**KIRKLEES METROPOLITAN COUNCIL
INVESTMENT & REGENERATION SERVICE**

**DELEGATED DECISION TO DETERMINE APPLICATIONS FOR
CONSENT, AGREEMENT OR APPROVAL REQUIRED BY CONDITION**

Reference No:	2025/44/90119/E
Site Address:	Yew Tree Farm, The Village, Farnley Tyas, Huddersfield, HD4 6UQ
Description:	Discharge of details reserved by conditions 3 (Phase 2 Report), 4 (Remediation Strategy), 7 (CEMP), 19 (Window Details), 21 (Roofing Materials), 22 (Walling Materials), 23 (Mortar Specification), 24 (Materials (plot 15)), 29 (Boundary Treatment) on previous permission 2021/93006 for conversion of existing barn to form 8 dwellings, erection of 9 dwellings, demolition of redundant agricultural buildings and associated works (Listed Building within a Conservation Area)
Recommending Officer:	Katie Chew

Second Officer Report

TYPICAL SECTION BOUNDARY RETAINING WALL - 1:20 @ A1

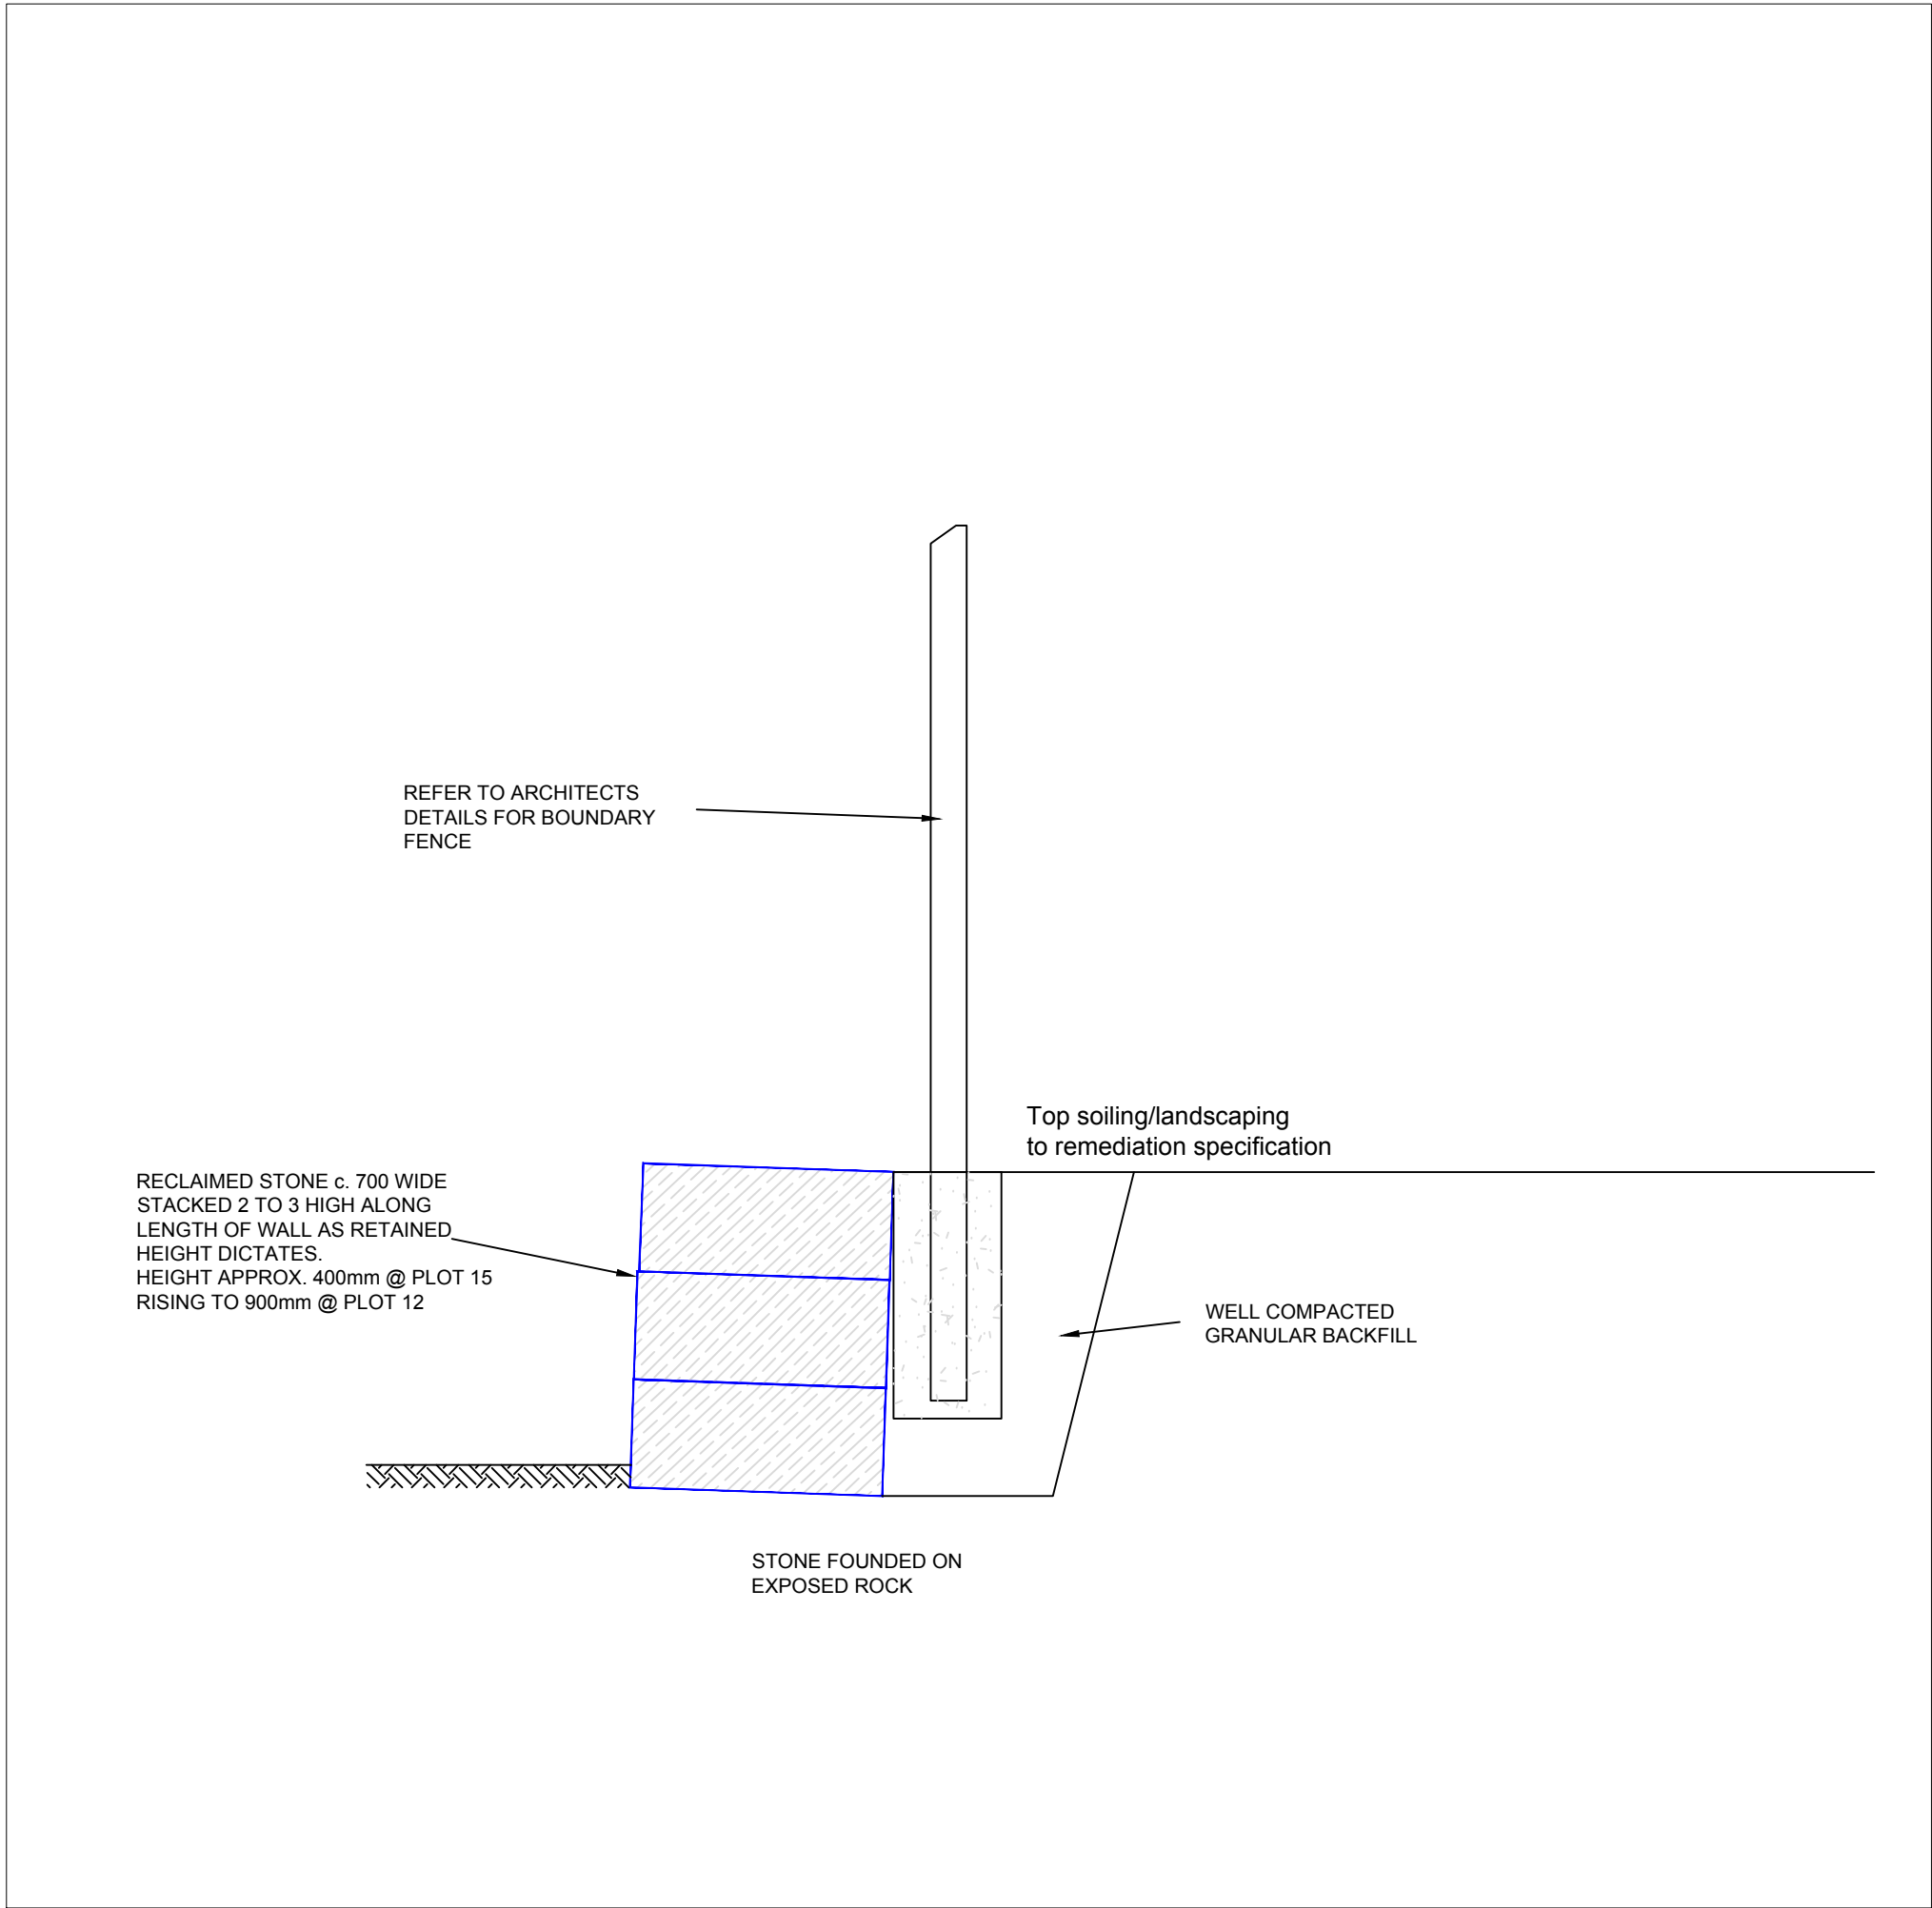
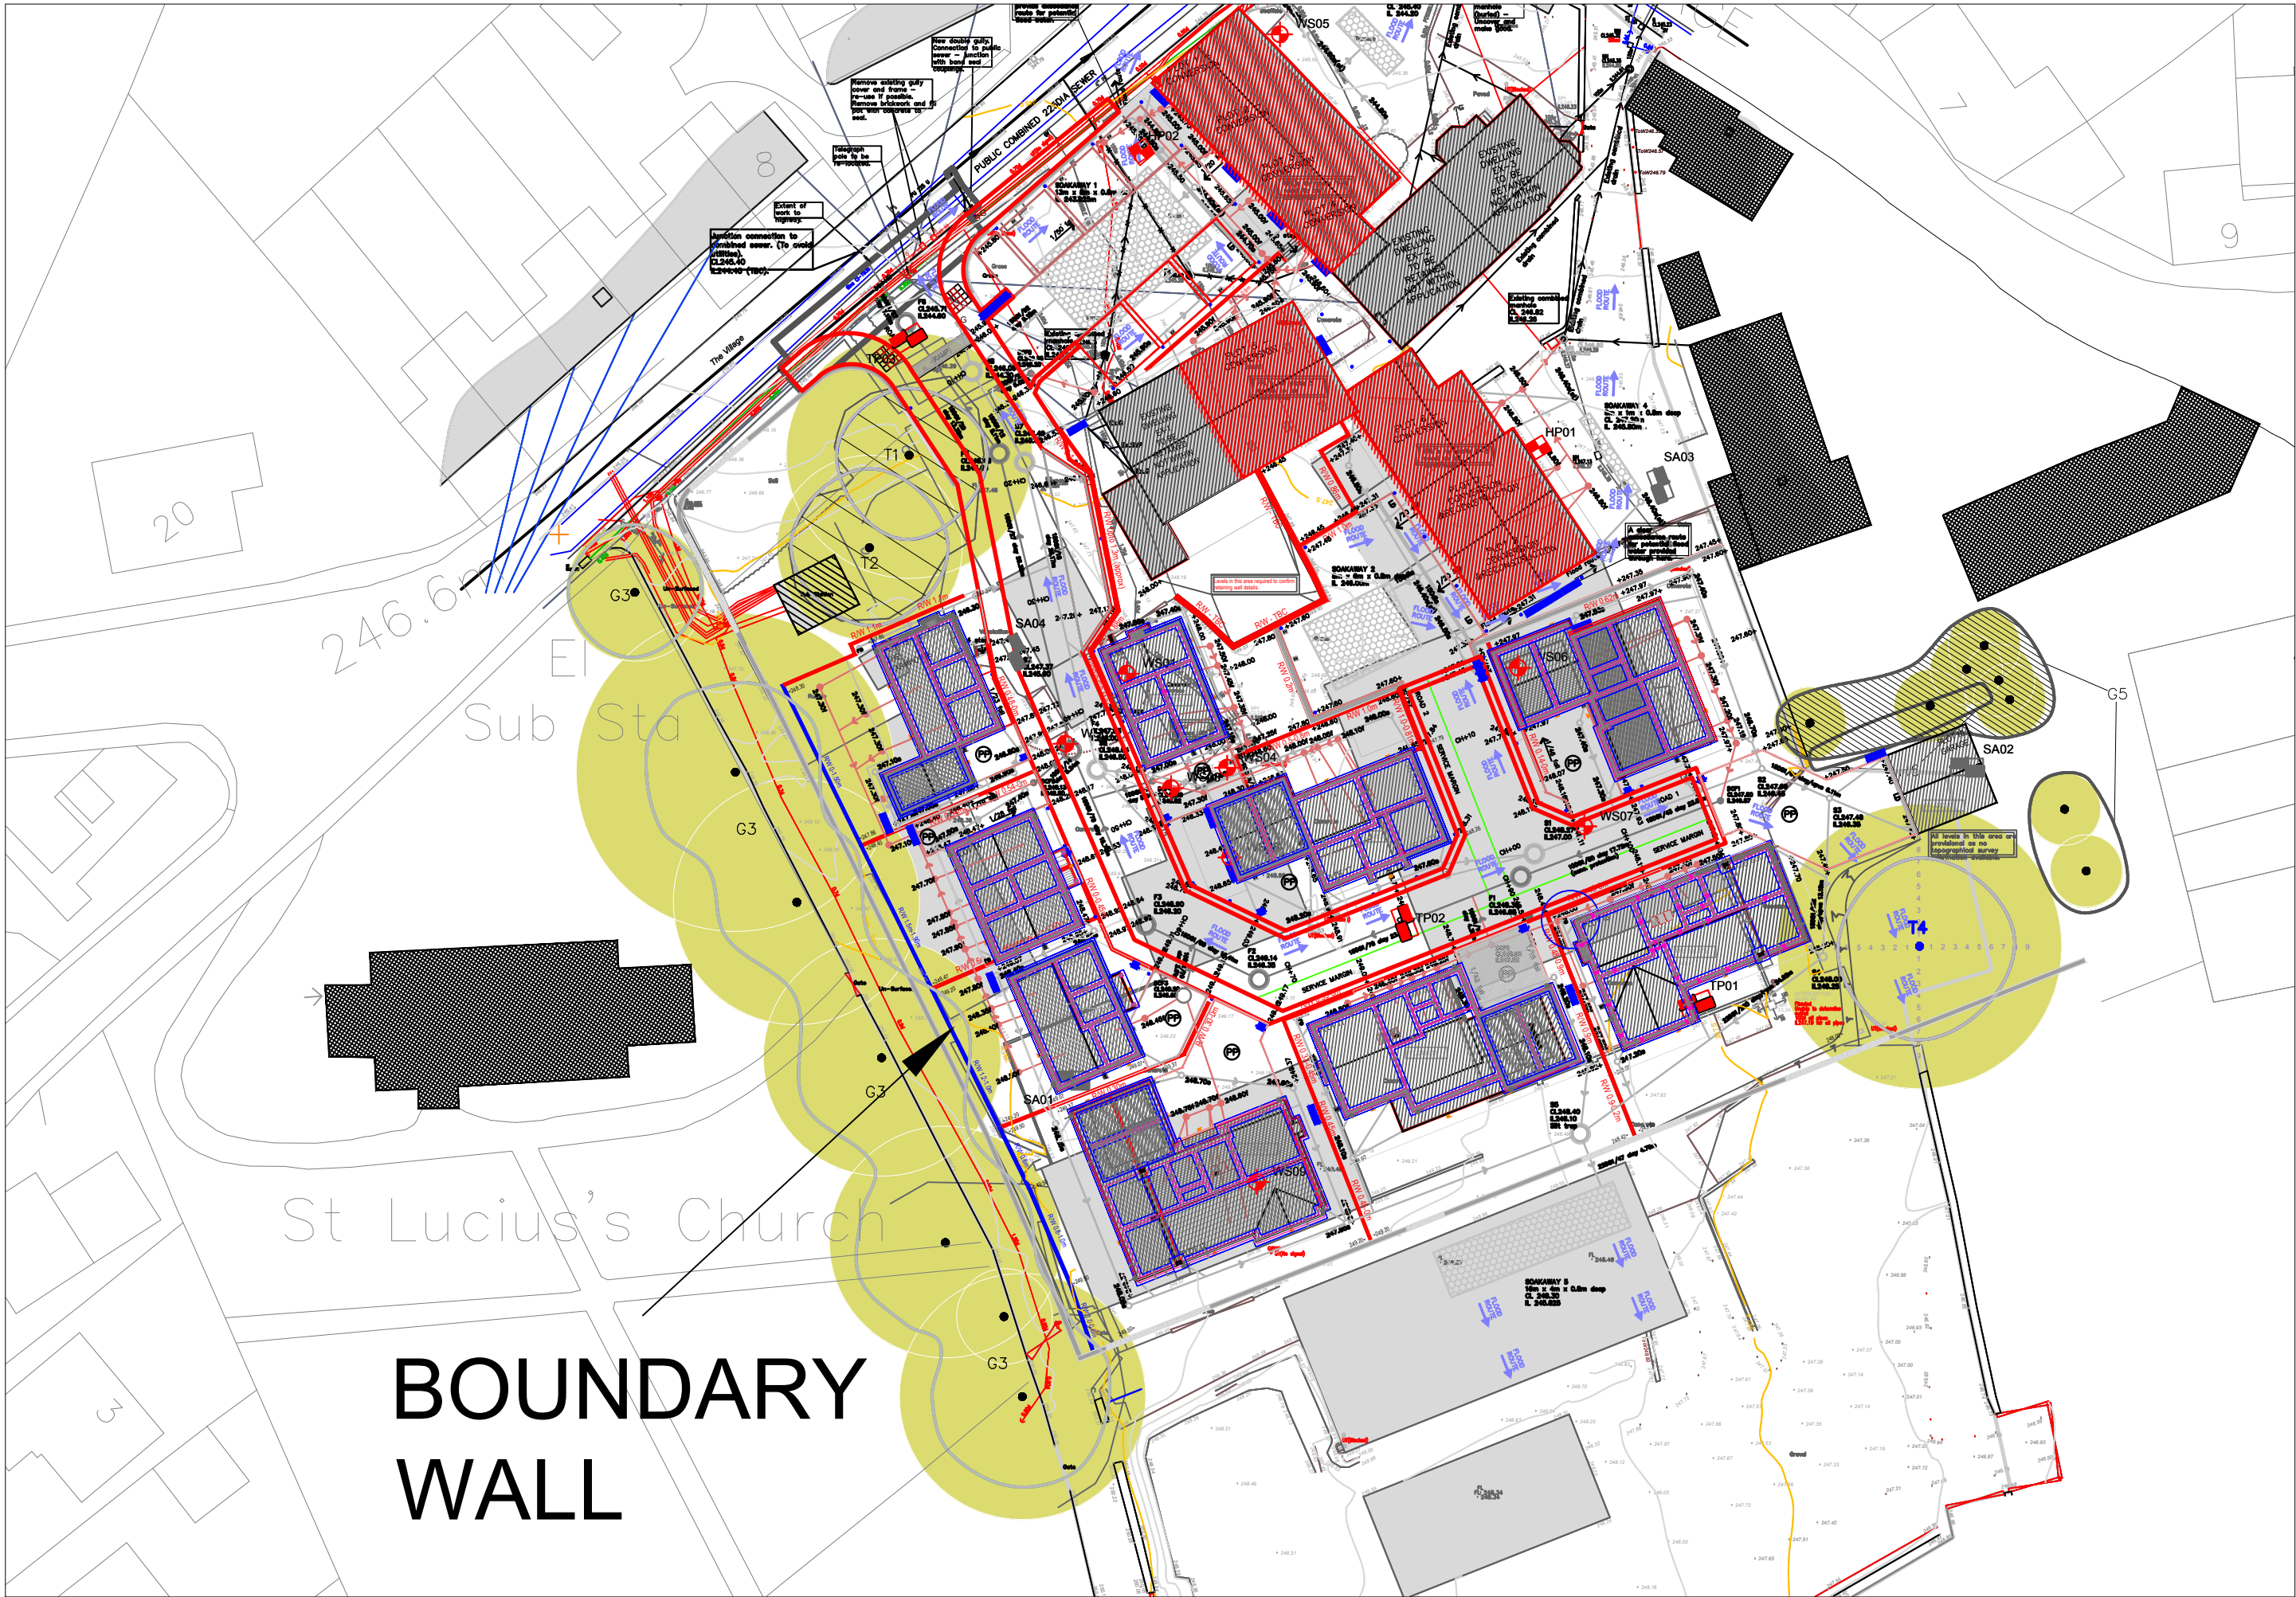
I would like to advise that condition 29 (Boundary Treatment) cannot be discharged pending the formal technical approval of design of proposed retaining walls via submission of AIP/s.

Photo 36: Original position of WS01 - now covered with hardstanding.

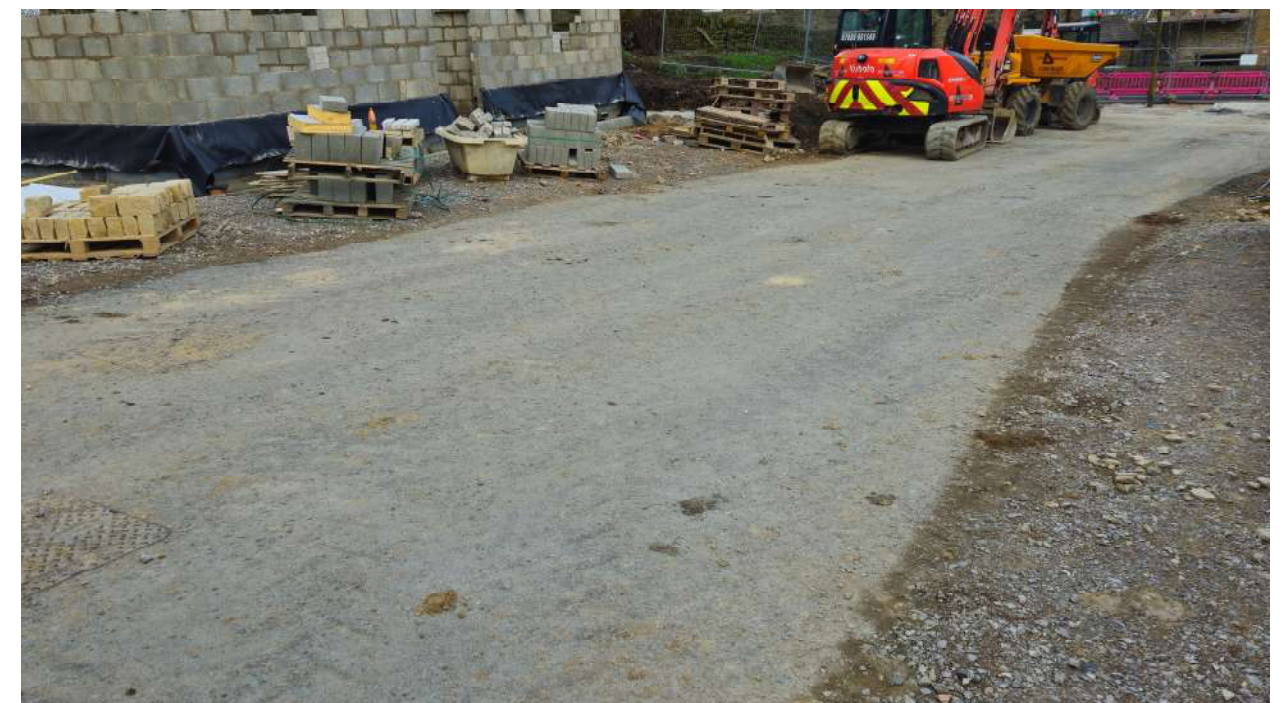
Borehole WS01 (Lithos Report No. 3381/2, July 2021) recorded made ground to 0.2m bgl, followed by clay and weathered Grenoside sandstone. RGS states the WS01 location is now covered with hardstanding. We seek clarification as to where the impacted made ground has gone?

PROPOSED FENCE DETAILS.

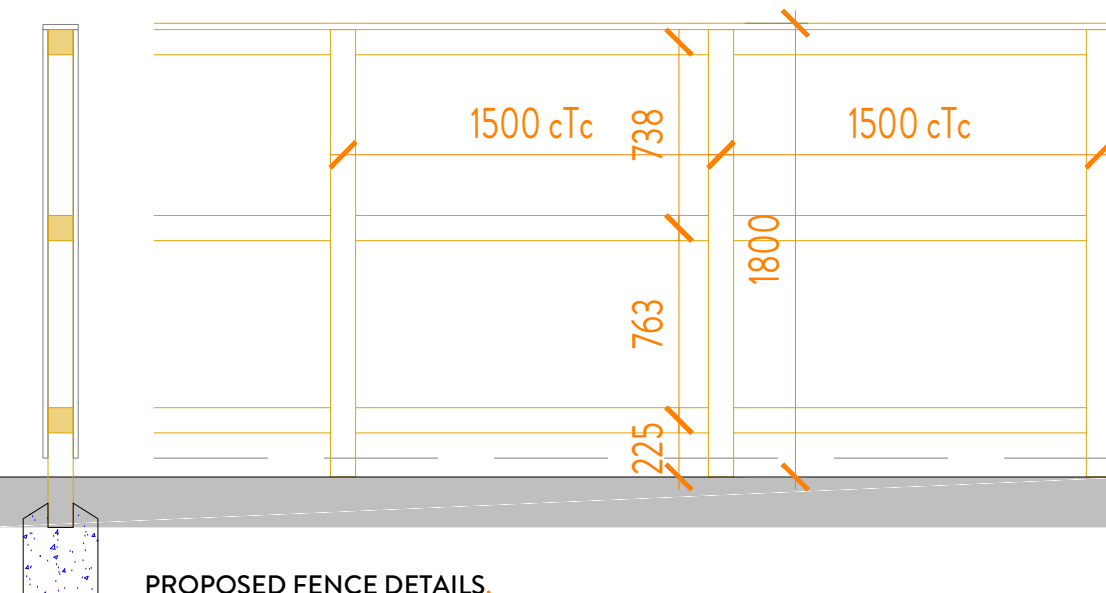
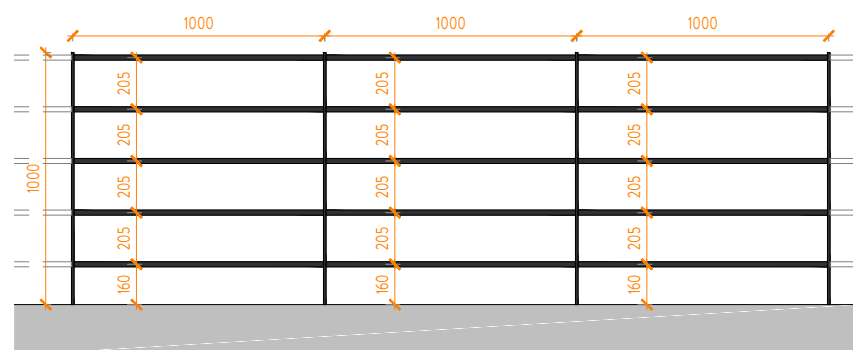
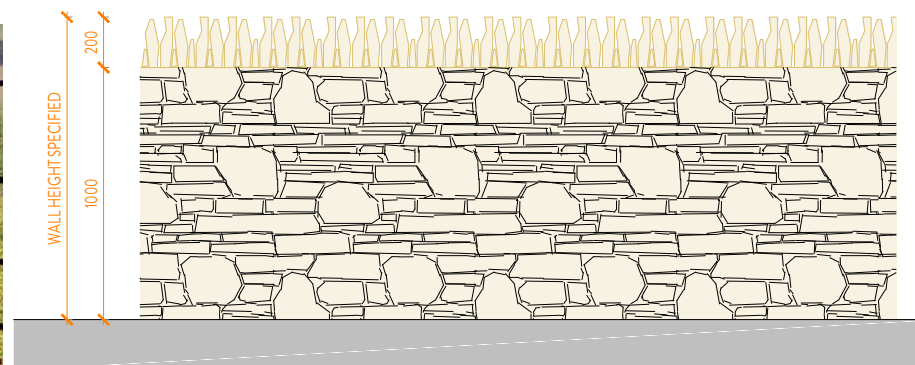
The proposals seek to install a mix of 1.2m high dry-stone walling, 1.8m high back-to-back timber fencing and 1m high metal feature railings throughout the site. Drystone wall under build is proposed along the western boundary. These details are broadly in line with the boundary treatments approved within the original permission. However, it is noted that following discussions with KC Conservation & Design and the applicant's agent, it was agreed that the originally submitted timber fencing adjacent to the substation and Plot 5, be amended to railings in the interests of visual amenity.
